Application Ref:	3/2021/0552	 Ribble Valley Borough Council www.ribblevalley.gov.uk
Date Inspected:	28/06/2021	
Officer:	RB	
DELEGATED ITEM FILE REPORT:		APPROVAL

Development Description:	Proposed first floor rear extension. Resubmission of 3/2020/1077
Site Address/Location:	11 Mellor Brook, Mellor Brook, BB2 7PH

REAR ELEVATION (SOUTH) PROPOSED

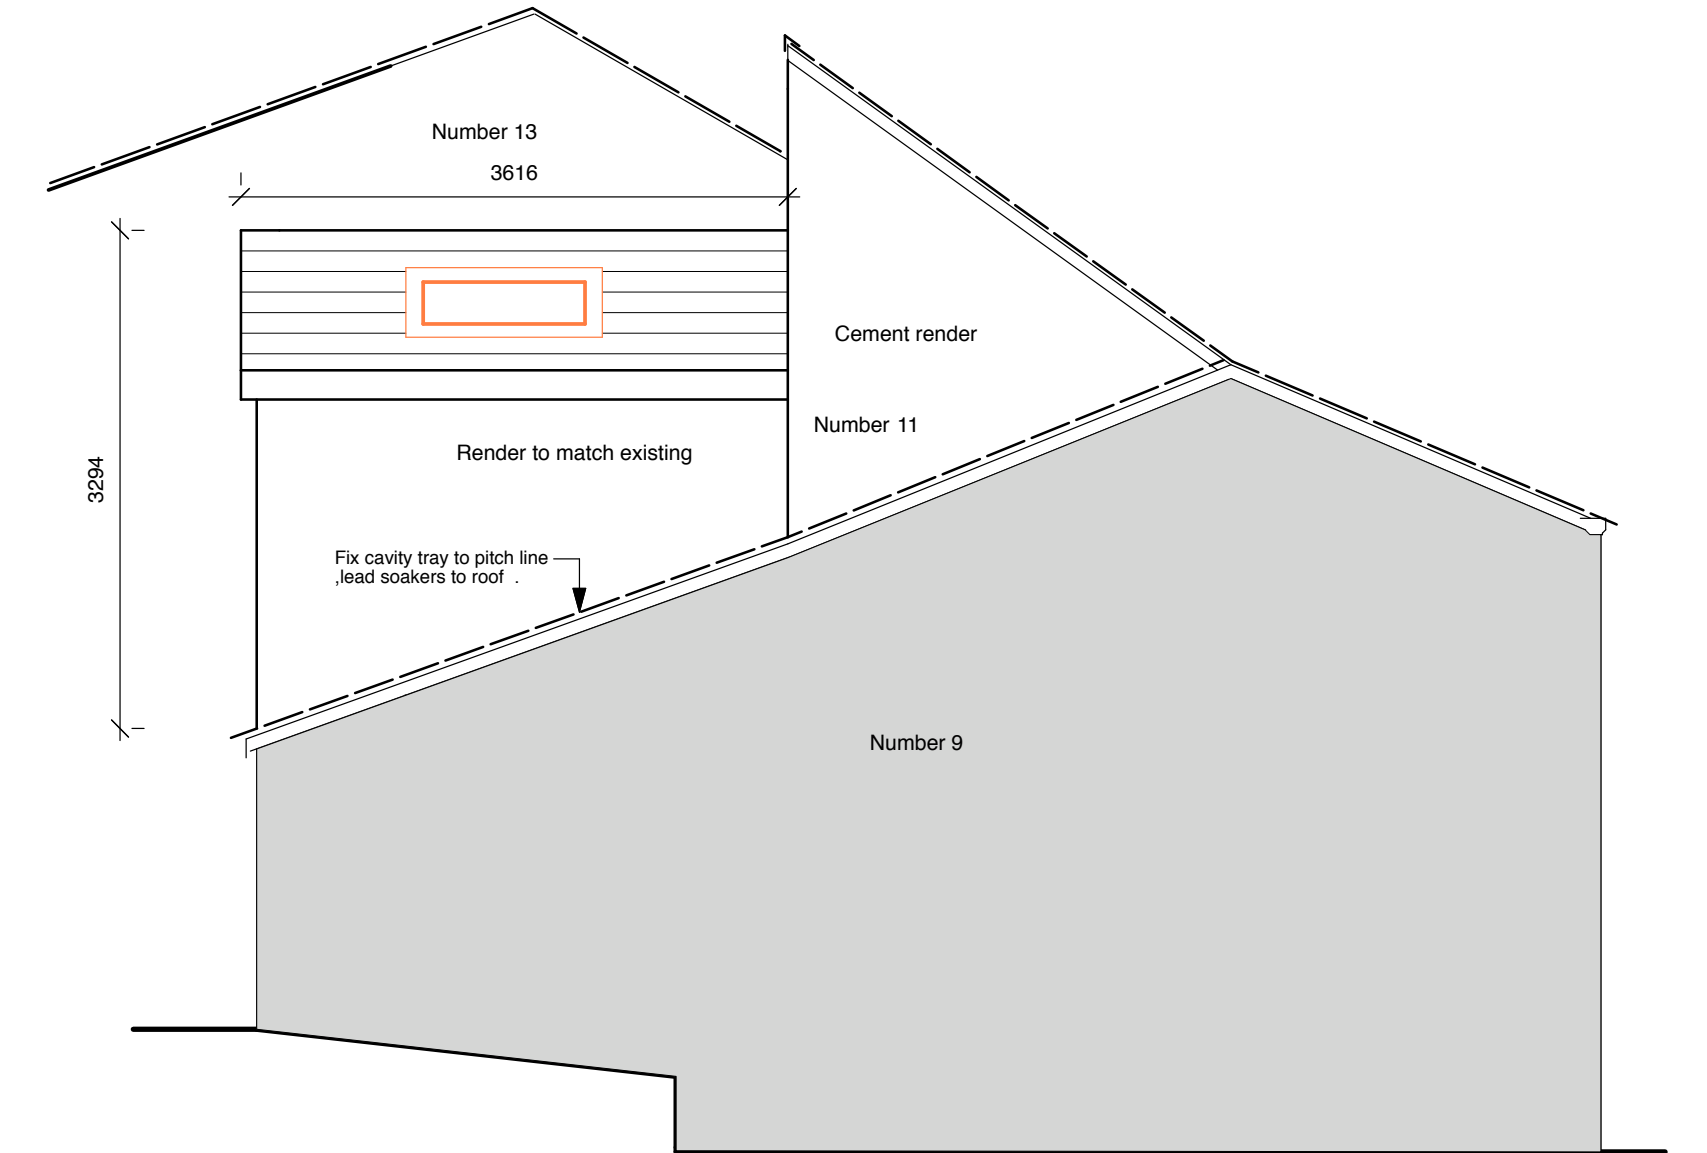
The development was previously refused as it was considered that the balcony proposed on the rear elevation would result in a detrimental loss of privacy to no 9 and 13 Mellor Brook and 4 and 5 Woodfold Close. The resubmitted proposal has removed this balcony and a single roof light is proposed in the east roof slope. This roof light would not result in any loss of privacy to the neighbouring dwellings. As such the revised proposal shares an acceptable relationship with the neighbours.

The adjacent dwelling at no 9 benefits from a first-floor extension that forms a south facing gable that is of a similar design to the proposed development. Therefore, the extension would not appear of character in the area and would partially screen an existing first floor extension that has a Skillion roof. The partial screening of the Skillion roof would be considered a benefit to the visual amenity of the area. The proposed first floor extension would remain subservient to the main roof at the ridge of the gable is set significantly lower than the ridge of the terrace row and the eaves match the eaves of the two-storey element of the property (front).

SIDE ELEVATION (EAST) PROPOSED

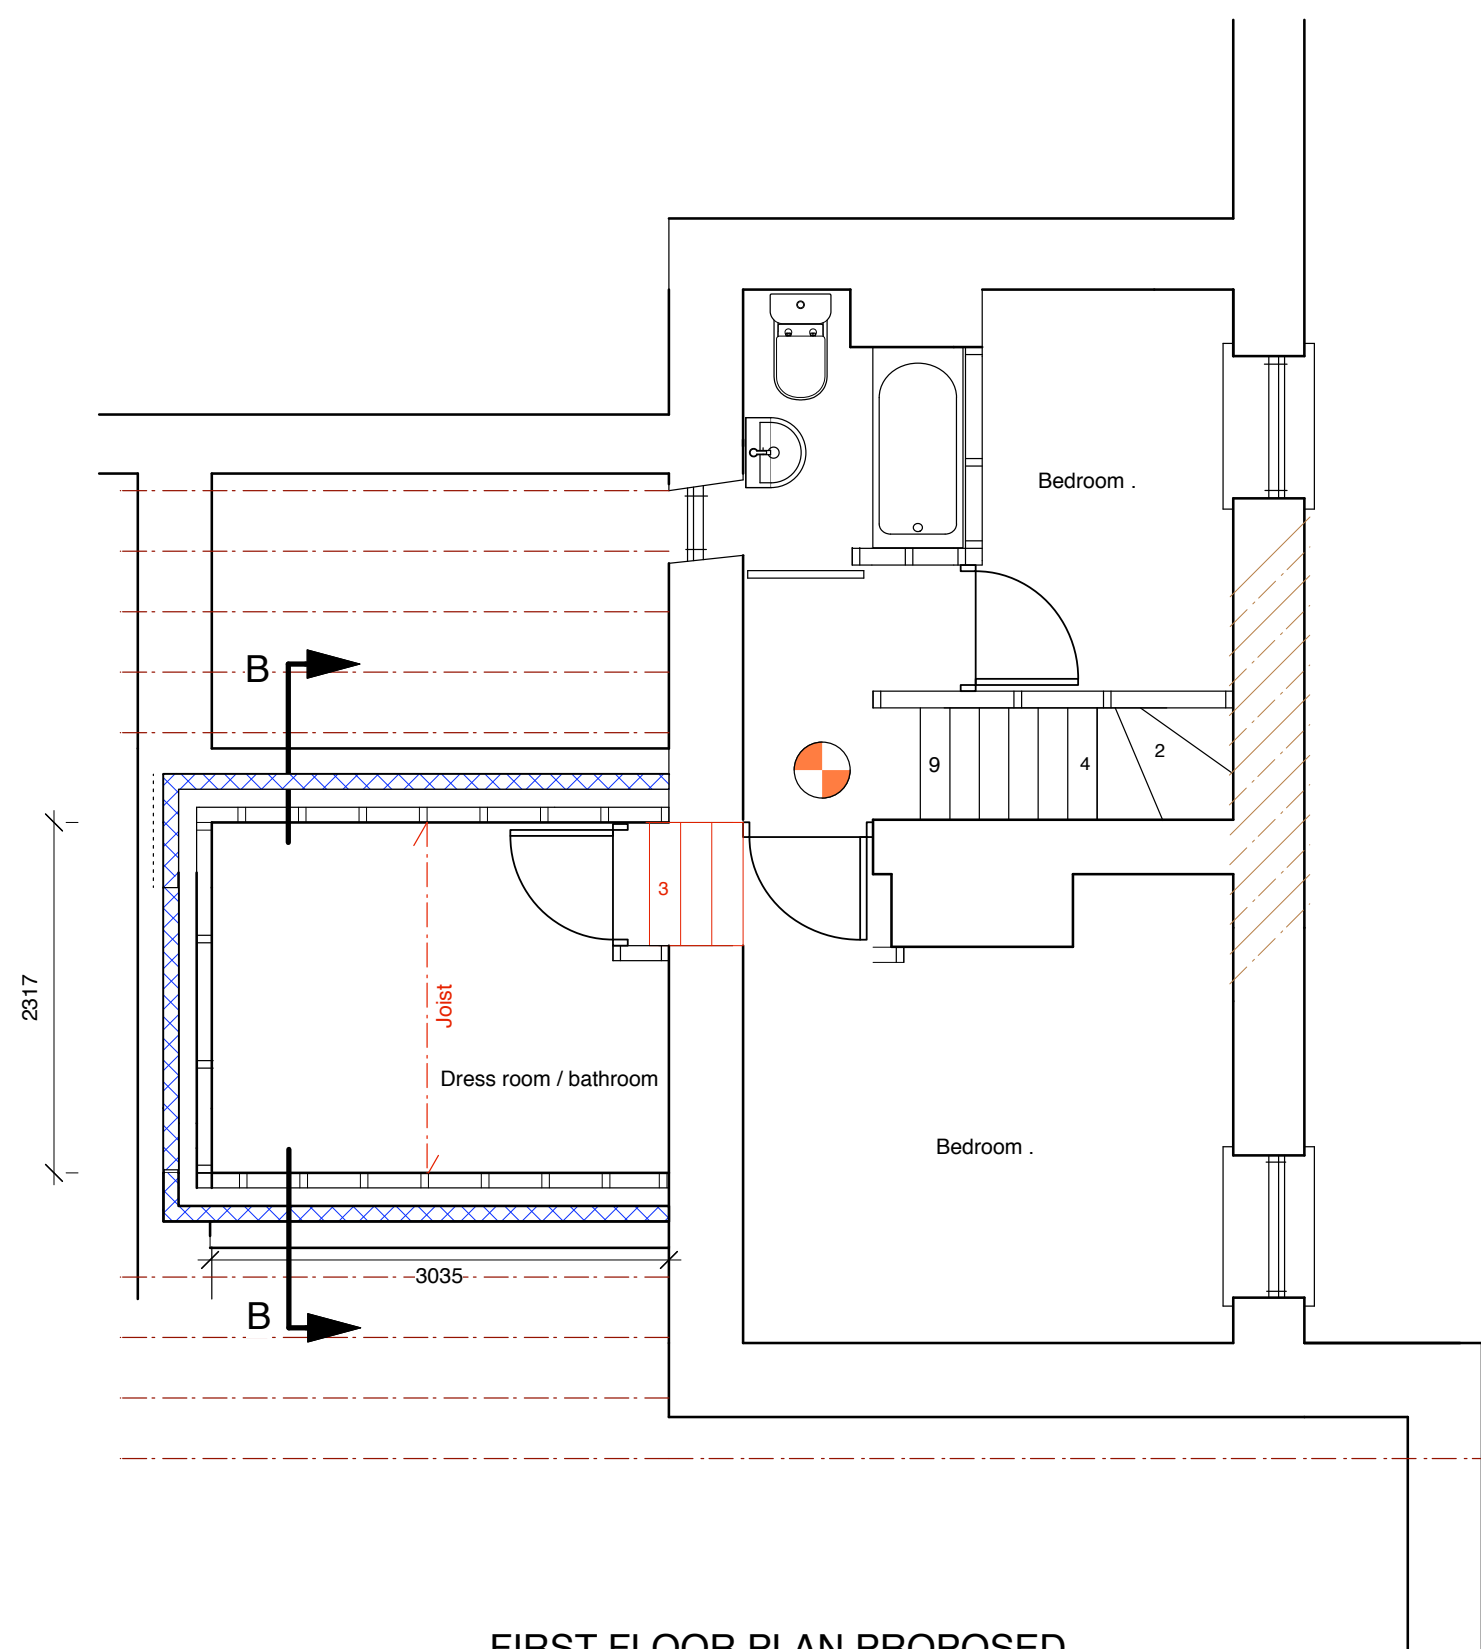
Consent is sought for the erection of a first-floor extension to the rear of the property. The first-floor extension will extend off the eaves of the existing property to form a south facing gable. The extension will project off the roof at first floor by 3m measuring 2.9m in width. The eaves of the new gable will measure at approximately 4.2m from ground level and approximately 5.3m at the ridge when measured from ground level. A rooflight is proposed on the east roof slope.
